Recommendation Report for Planning Permission for Works or Extension to a Dwelling

REF NO: P/36/22/HH

LOCATION: Sefter Cottage
Pagham Road
Pagham
PO21 3PX

PROPOSAL: Erection of two storey rear extension.

PROPOSED WEST ELEVATION 1:100

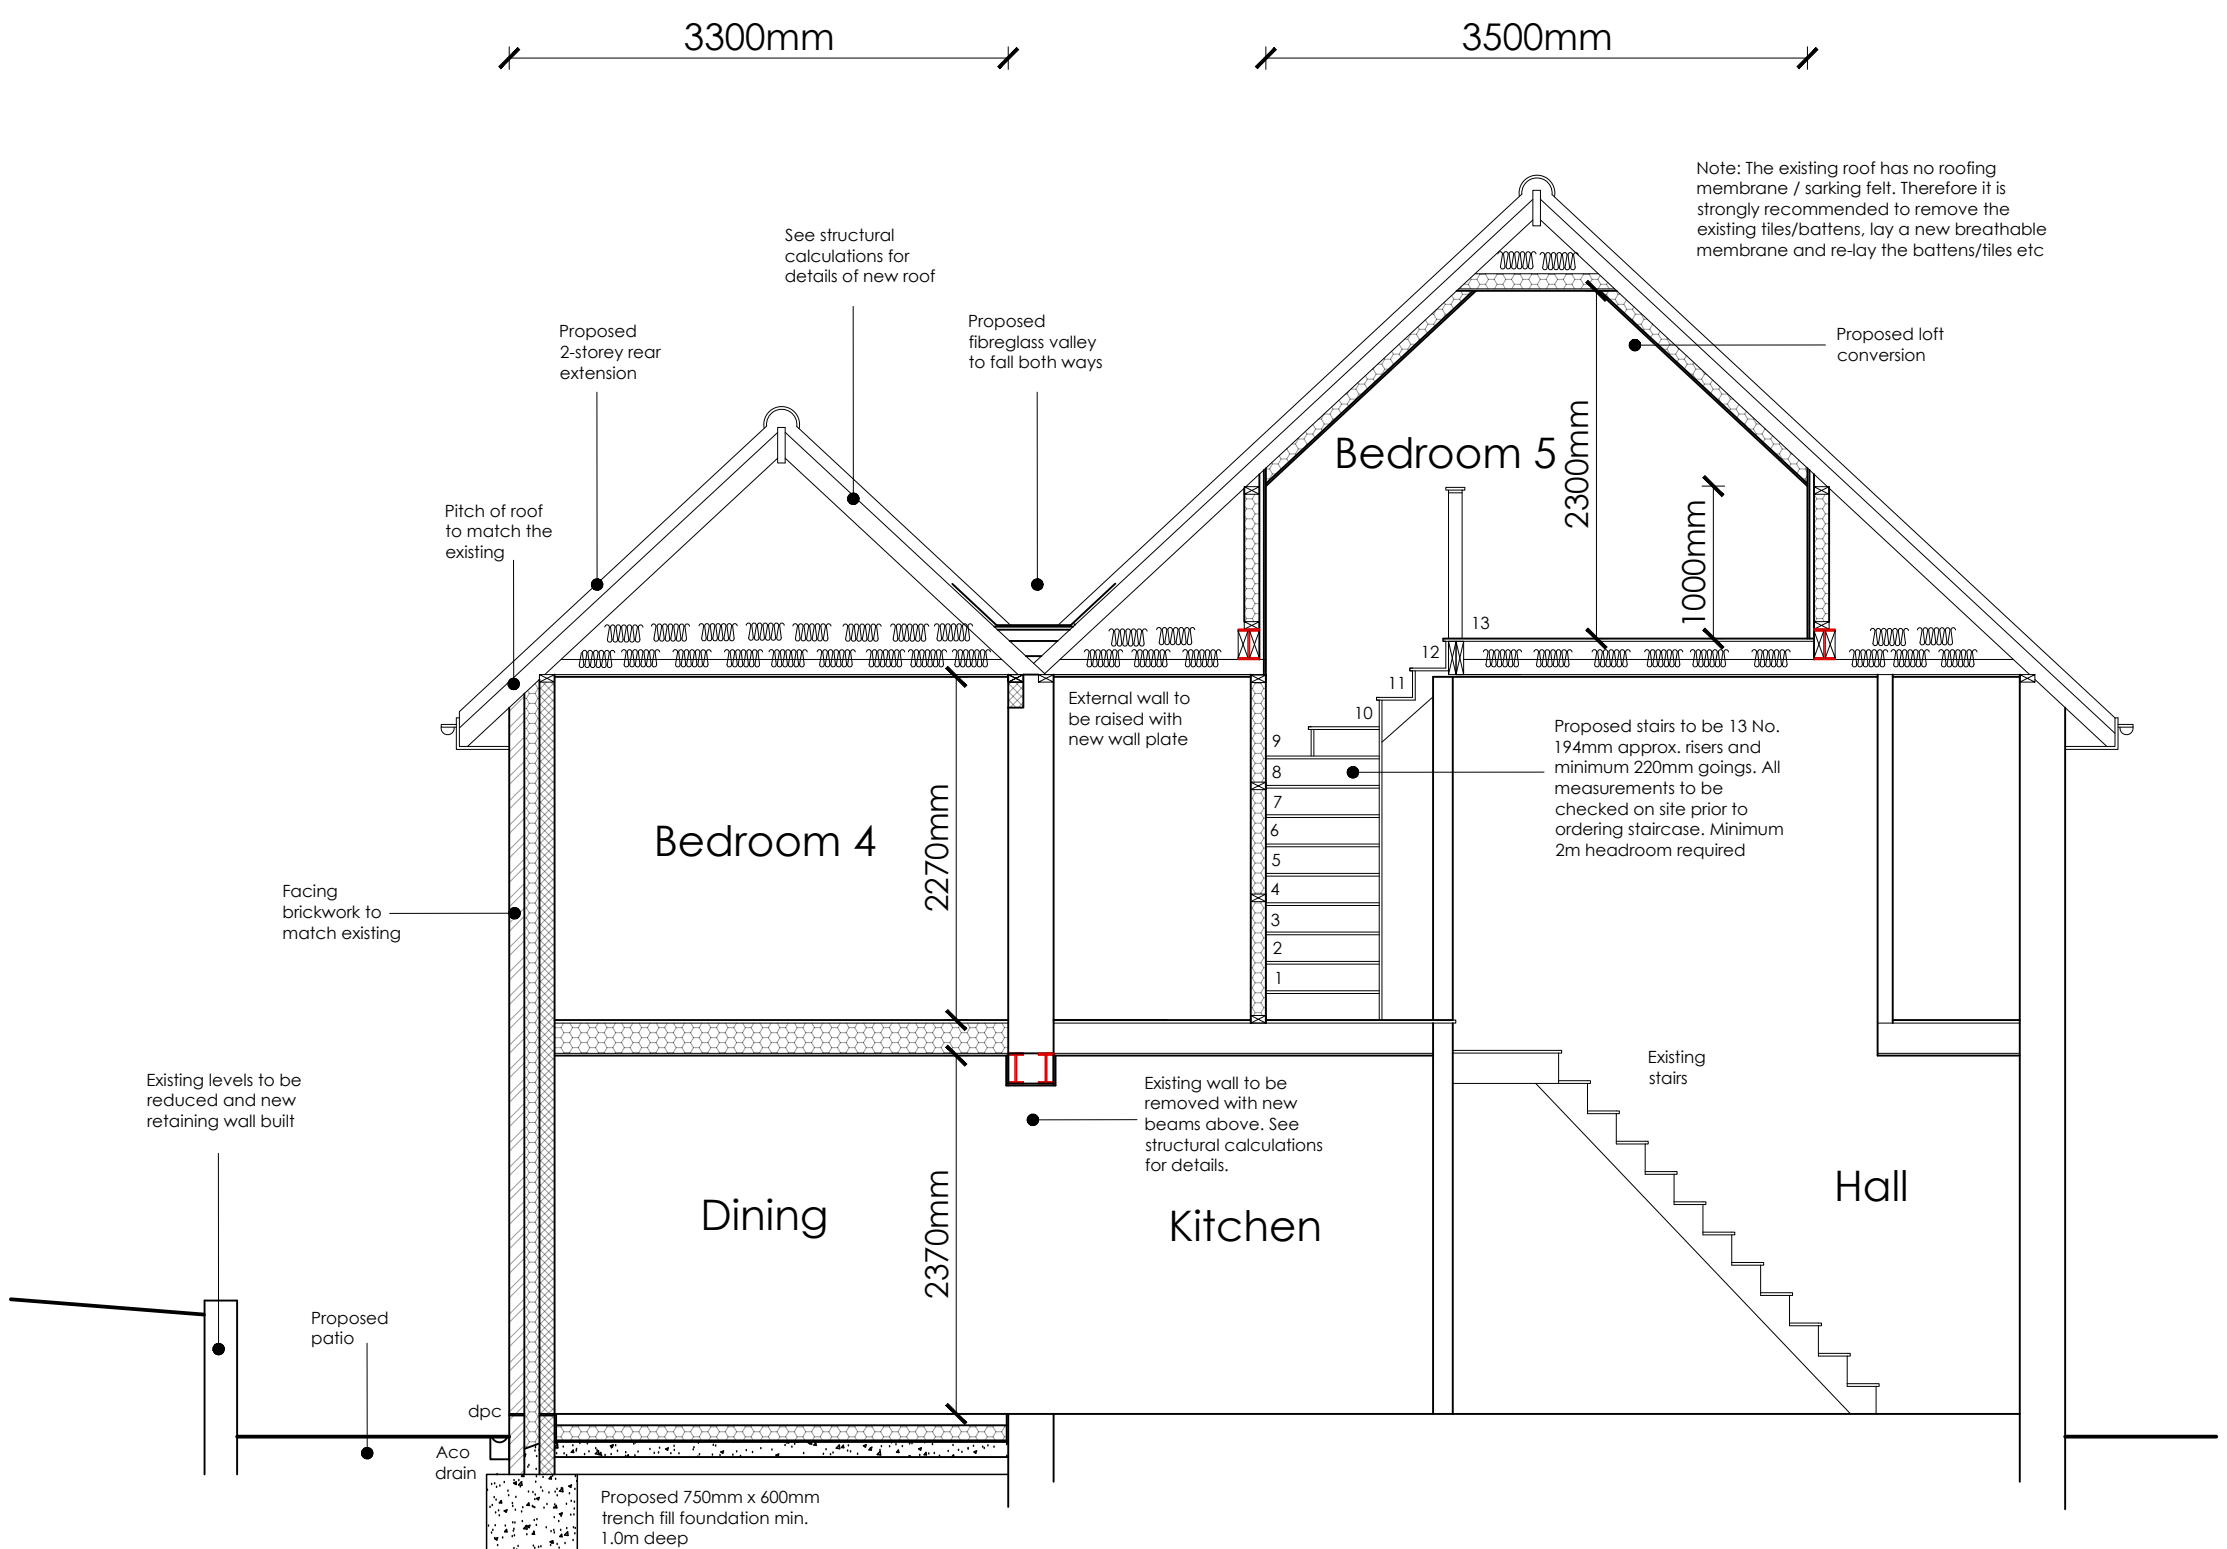
The extension has a modest depth at 3.3m. The extension is well integrated and features a pitched roof. This is set below that of the ridge of the main dwelling and helps to ensure the proposal appears a subservient addition.

The extension has a depth of 3.3m and run along the full rear elevation. The ridge will sit approximately 2.2m below that of the main property with the eaves meeting with the host dwelling.

The two storey addition will feature 4 first floor windows to the rear elevation. This will provide views over the rear garden of the property. Due to their position, any views over the neighbouring garden are largely restricted when looking at a 45 degree angle and would not result in adverse overlooking. There will also be one additional window serving a bathroom to the first floor northern elevation. The window will not give rise to any overlooking with no nearby dwellings to this elevation.
